**Our Case Number:** ABP-318446-23

**Re:** Proposed construction of Coumnagappul Wind Farm consisting of 10 no. turbines and associated infrastructure.

Submission to An bord Pleanála Reference number: 318446

The construction of 10 wind turbines and related works at  
Counagappul Wind Farm, Co. Waterford

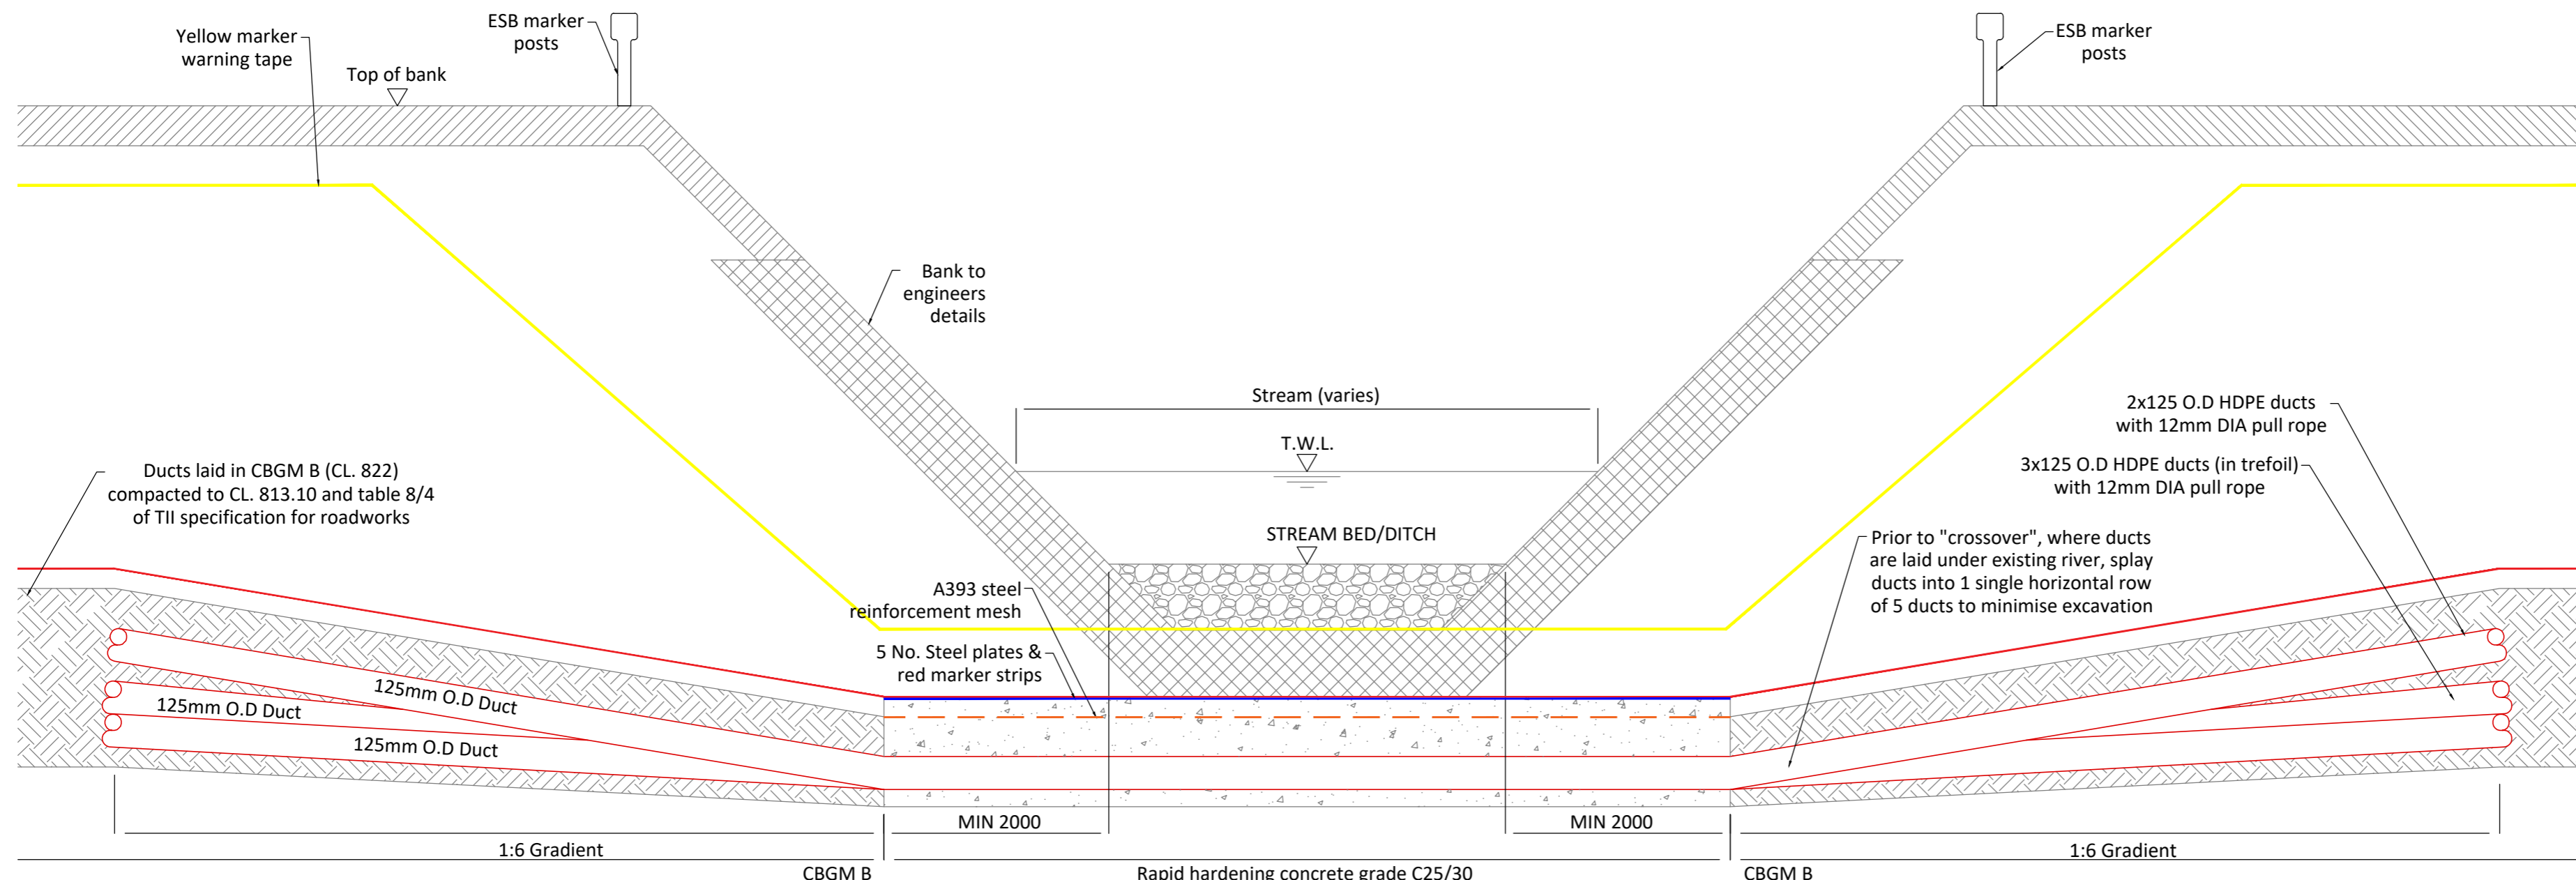
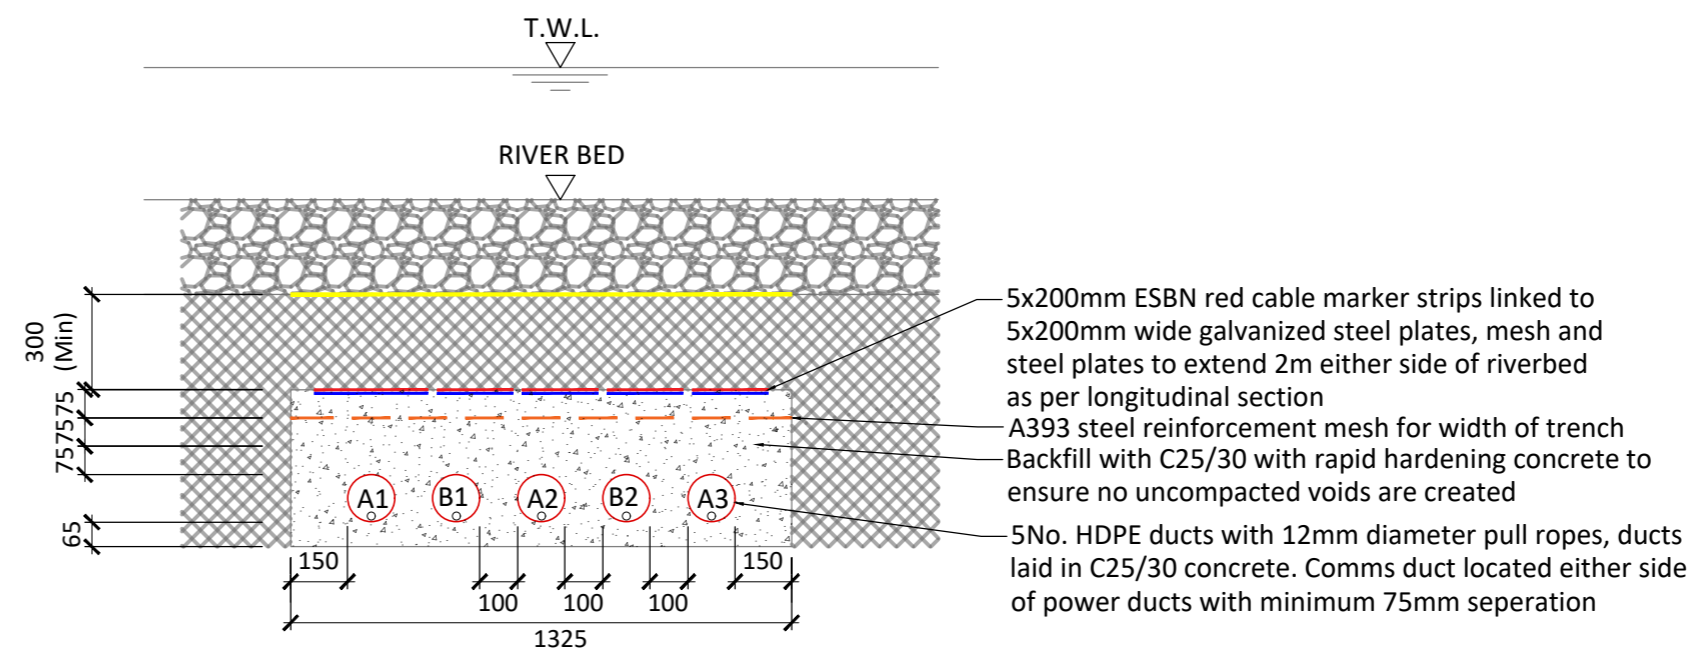
The proposed grid connection is 22.47 kilometres in length running from the source of the river Colligan to Dungarvan 110KV substation. I emphasise the word proposed as this is not a definite route. In the AA screening and NIS report the developer admits that this project involves watercourse

crossings and a bridge crossing, this crossing requires drilling the waterbed yet they haven't supplied a detailed construction method statement to accompany the application.
